**Norfolk Vanguard Offshore Wind Farm (EN010079): Written Statement**

### **Written Statement by Highways England**

**16 January 2019**

Drawing file: published-documents / EN010079-001867-Figure 24.05 Link Sensitivity.pdf

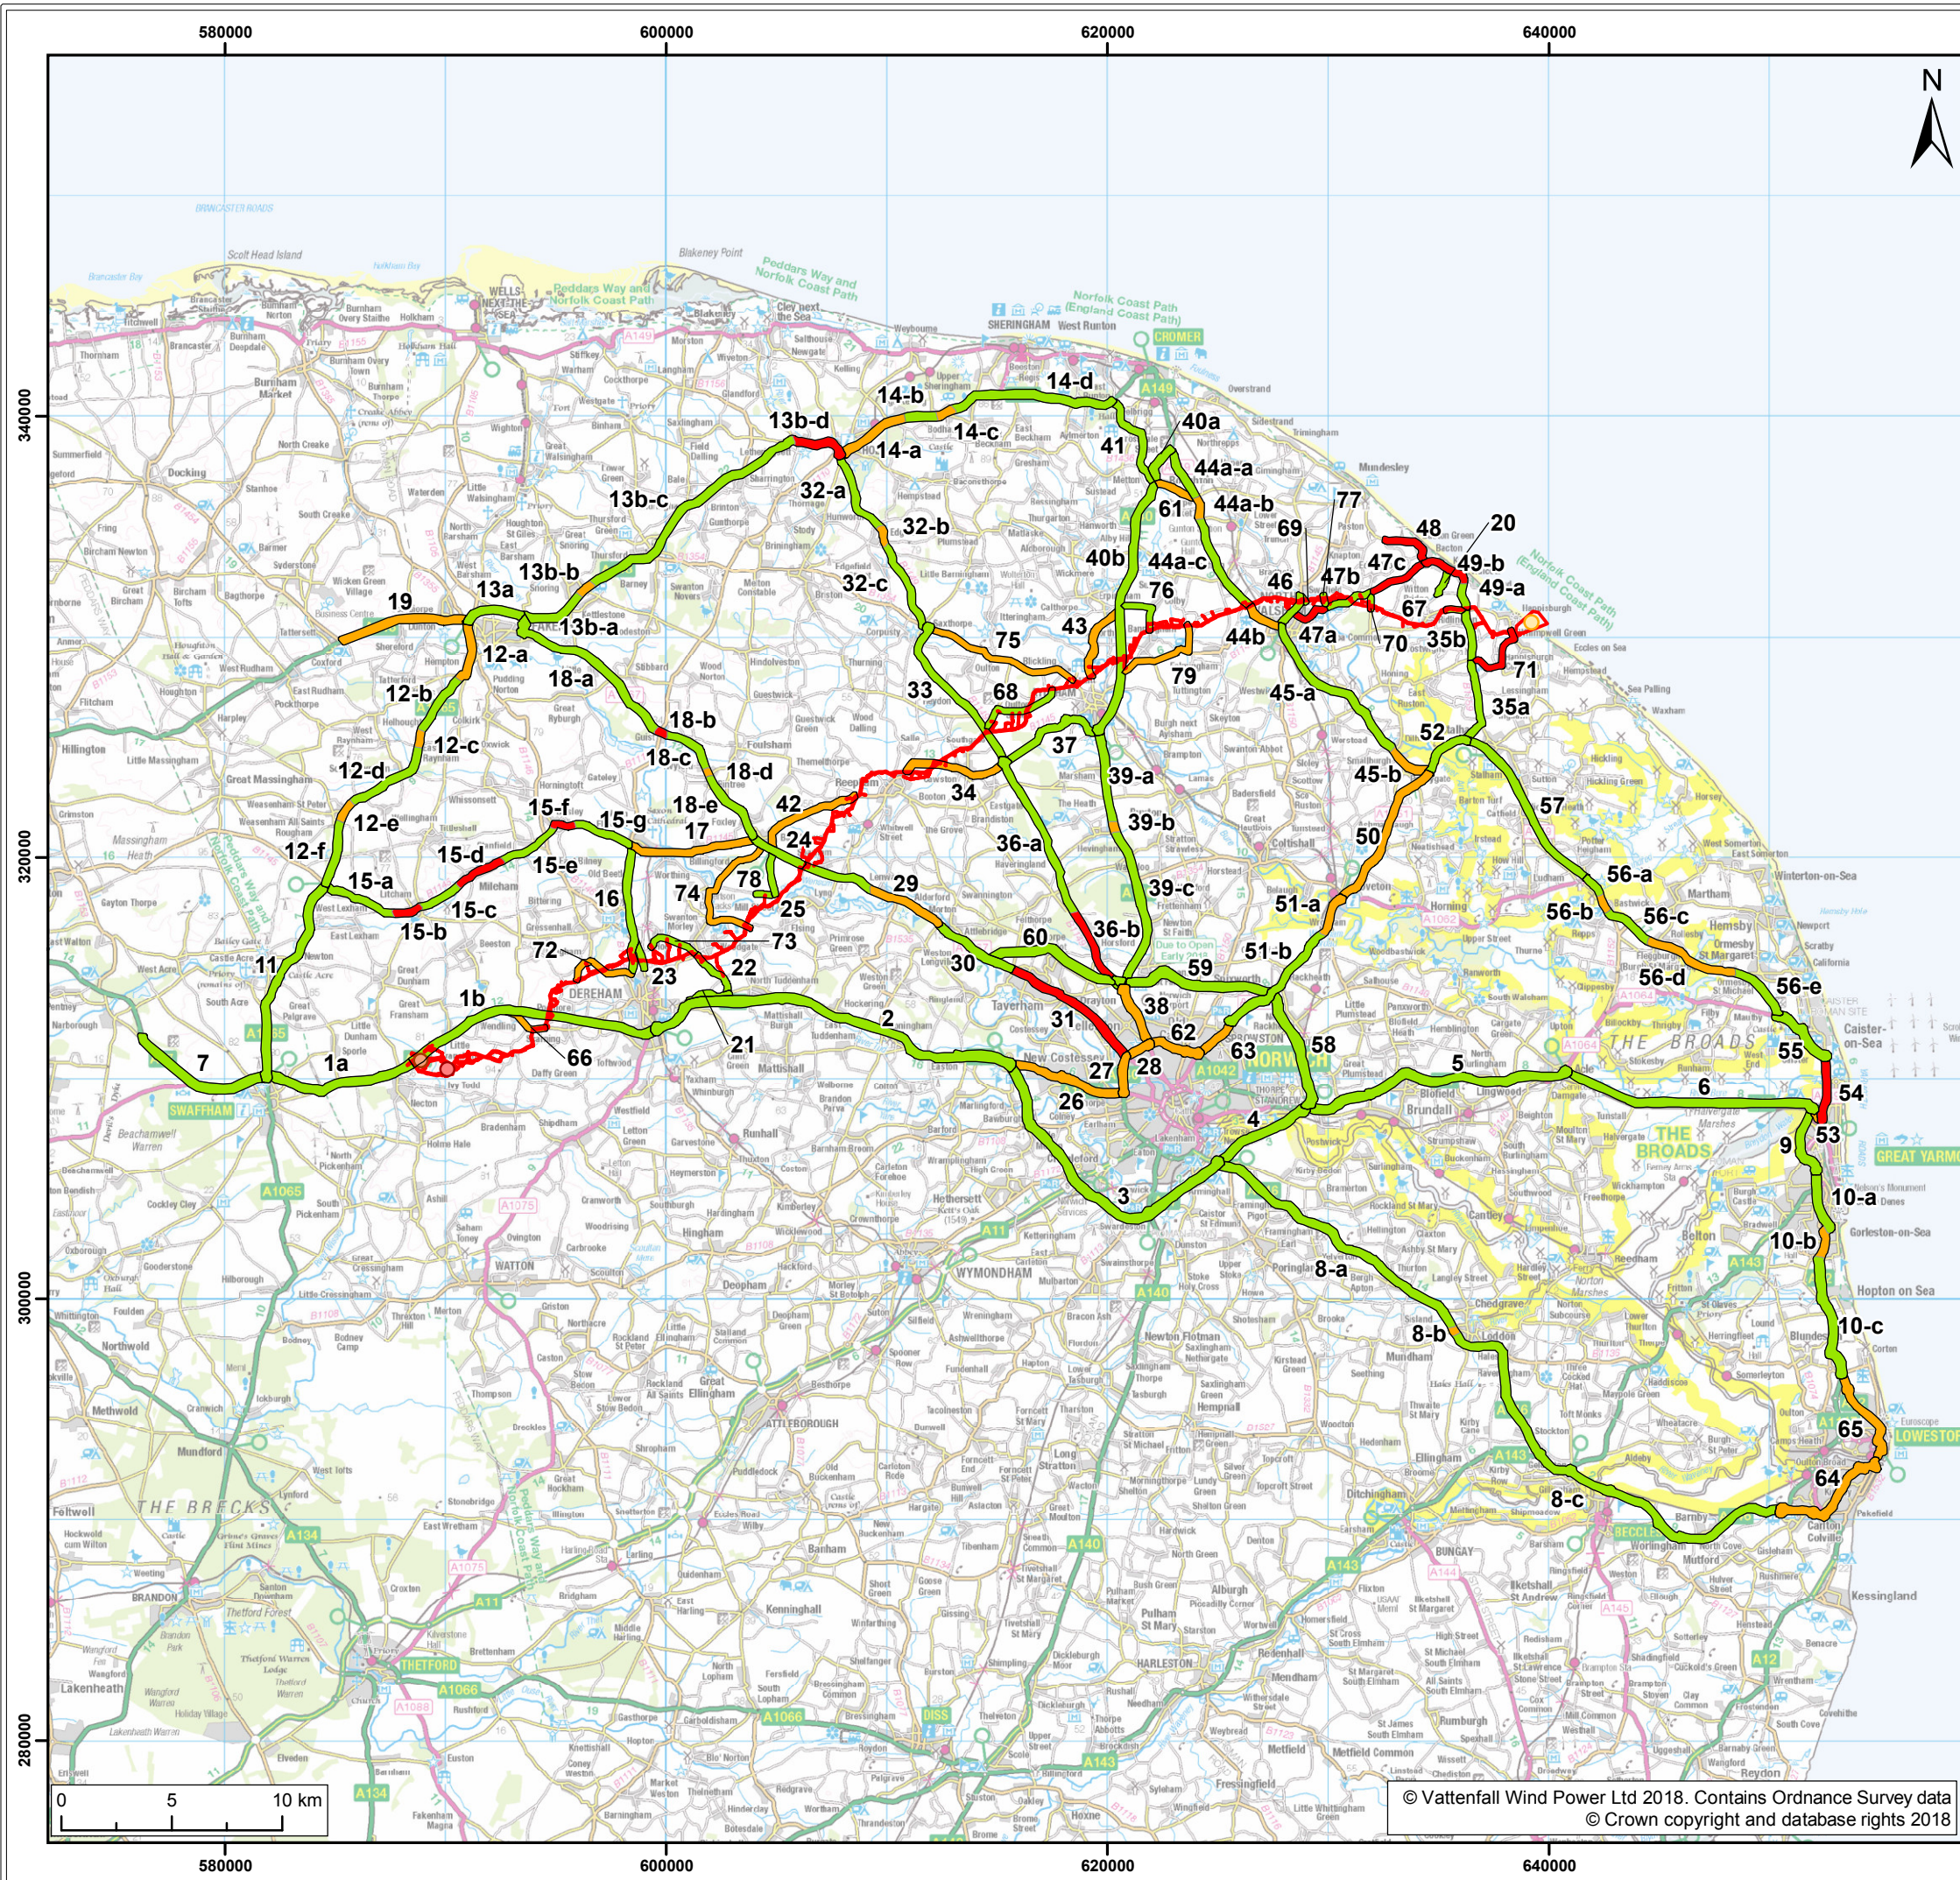
Highways England have no issues to raise with the link sensitivity categories relating to the SRN links shown in Table 24.9.
